Summary of Oral Statement and Undertakings given by Highway England at the Compulsory Purchase Hearing Held on Wednesday 2nd September 2015 to Landro Group and Hinchingsbrooke Water Tower Limited (HWT Ltd) (Registration ID Number 10030978)

Application by Highway England for an Order Granting Development Consent for the A14 Cambridge to Huntingdon Improvement Scheme

Land North of the Brampton Road, Huntingdon currently incorporating The Elevation Public Car Park, Redundant Water Tower and Reservoir

Drawing title: **LAND PLANS REGULATION 5(2)(i) SHEET 8 OF 40**

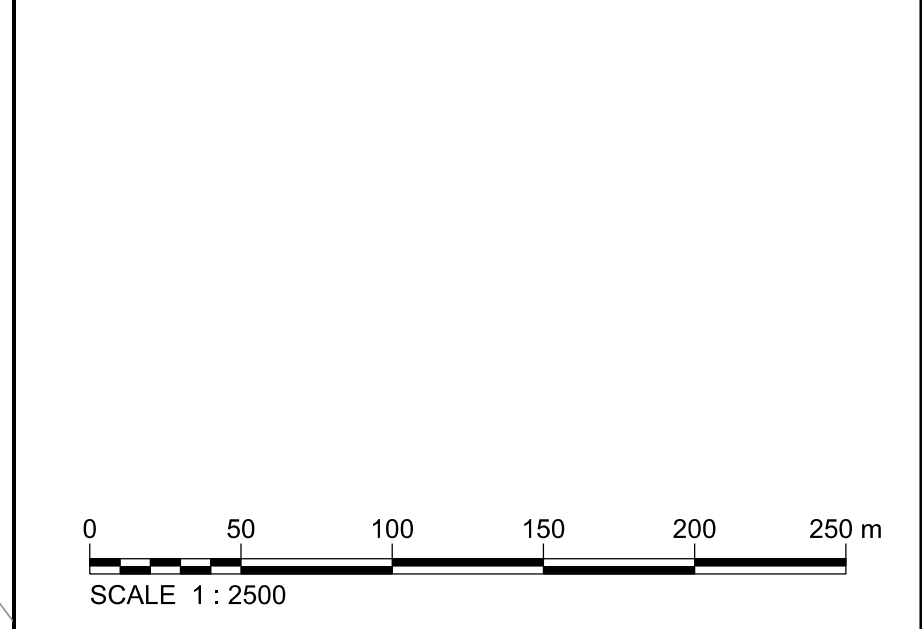
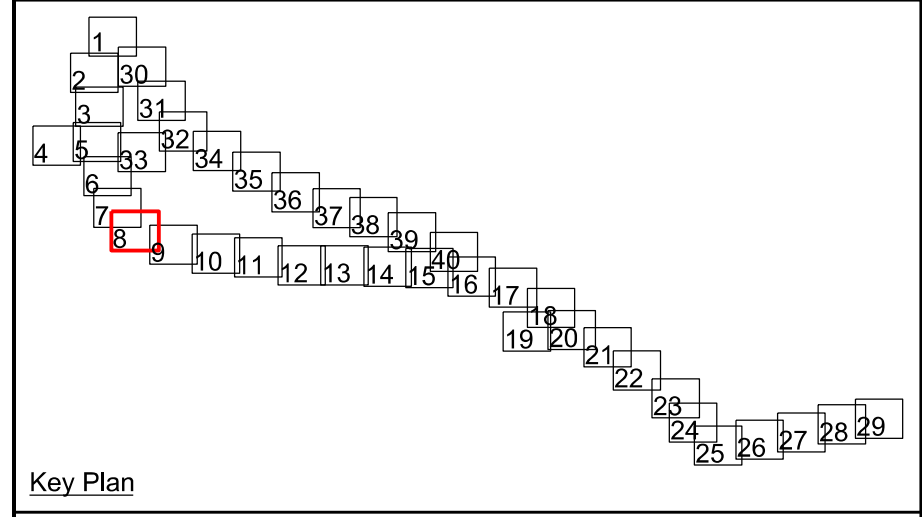
Ref: Plot 34/25d – Landscaping to the site frontage

The land take indicated on the CA plans extends across part of the joint access to the temporary car park and the water tower.

Ref: Plot34/4a – The area shown as landscaping immediately adjacent to the water tower (and identified as the hatched area on the attached plan annex A) is required for construction work and the ongoing maintenance of the water tower which because it is wider at the top than the bottom, over sails this area of land.

Ref: Plot 34/4a – The triangle of land underneath the existing flyover (identified as the area crossed hatched on the plan annex A) that is currently used for car parking and which forms part of the car parking provision for the water tower development.

This area is shown as being included within the CA with a future use for landscaping.

The removal of that car parking will reduce the level of car parking associated with the water tower that was shown on the approved layout plans. Copy attached under annex B.

The area immediately to the north where the embankment is to be removed is shown as landscaped and thus the exclusion of the triangle of land will have no impact in terms of visual amenity. On the other hand to remove the car parking would be prejudicial to the land owners interests and cannot be justified.

It was agreed that the CA plan be adjusted to ensure that the landscaping does not impede the access.

Action Points – HE to adjust the area to be landscaped in accordance with the existing access and footpath arrangements and HE to provide a draft agreement between the parties for the landscaping of the appropriate length of the frontage by HE as part of the A14 scheme and for the implemented landscaping to be the subject of a maintenance agreement to be undertaken by Mr Gredley/Landro..

Action Point – HE agreed to amend the plan and to exclude any planting and allow this area to be developed in accordance the Water Tower Planning Permission

Action Point – HE agreed to amend the plan and allow this land to be developed in accordance with the Water Tower Planning Permission.
